WEST SUSSEX COUNTY COUNCIL CONSULTATION

TO:	Arun District Council FAO: Amy Myer
FROM:	WSCC - Highways Authority
DATE:	12th October 2021
LOCATION:	Booker Hall Station Road Rustington BN16 3AY
SUBJECT:	R/203/21/PL Demolition of existing community hall and ancillary building and redevelopment of the site to provide a new community hall with supporting functions and office accommodation within a new 1.5 and 2 storey building with associated car parking area and landscaping.
DATE OF SITE VISIT:	n/a
RECOMMENDATION:	Advice
S106 CONTRIBUTION TOTAL:	n/a

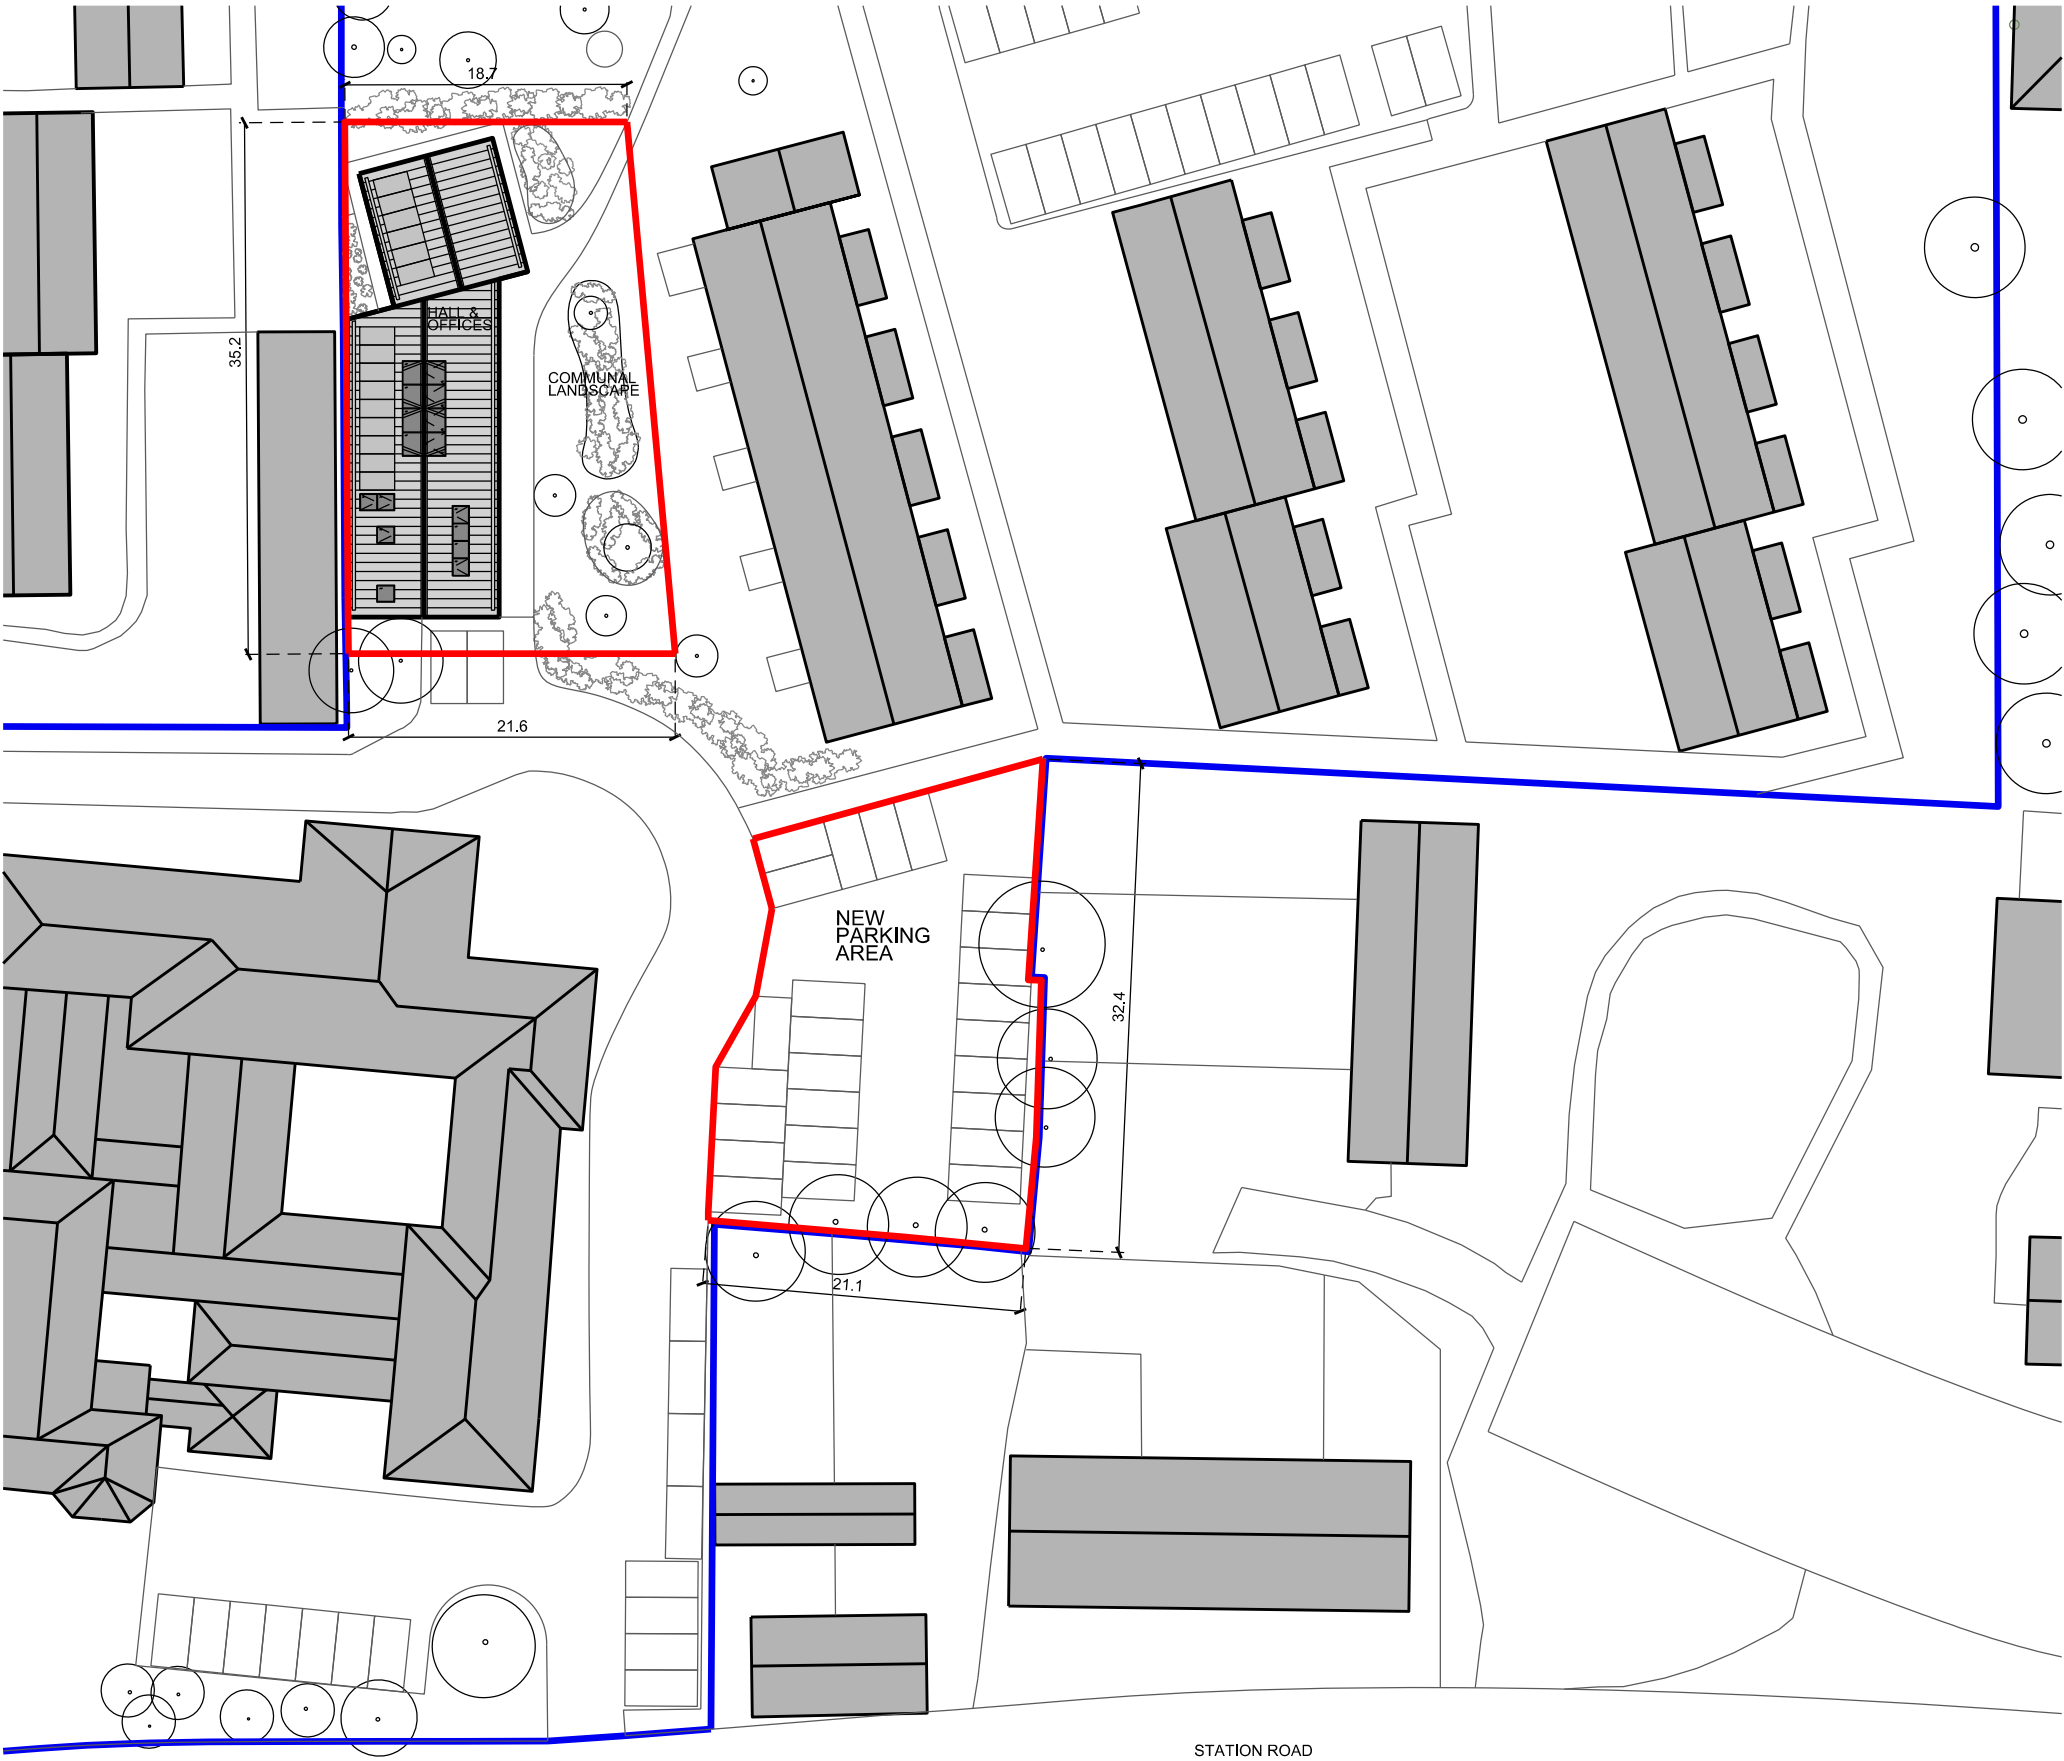
This application will not materially change traffic movements to and from the site, the new hall has a small overall increase in floor area over the current use, overall highway safety though is unlikely to be detrimentally affected. The access arrangements for both points remain as existing and appear to be operating safely based on the latest LHA accident data available. The provision of on-site parking is considered sufficient with the justification provided within the TN which includes swept path diagrams demonstrating that the arrangement works sufficiently. A condition should be applied to cover the changes to car parking and securing cycle parking. Finally the sites Electric Vehicle charging is considered sufficient for what is proposed.

No dwelling shall be first occupied until the car parking serving the hall has been constructed in accordance with plans and details to be submitted to and approved in writing by the Local Planning Authority. Once provided the spaces shall thereafter be retained at all times for their designated purpose.
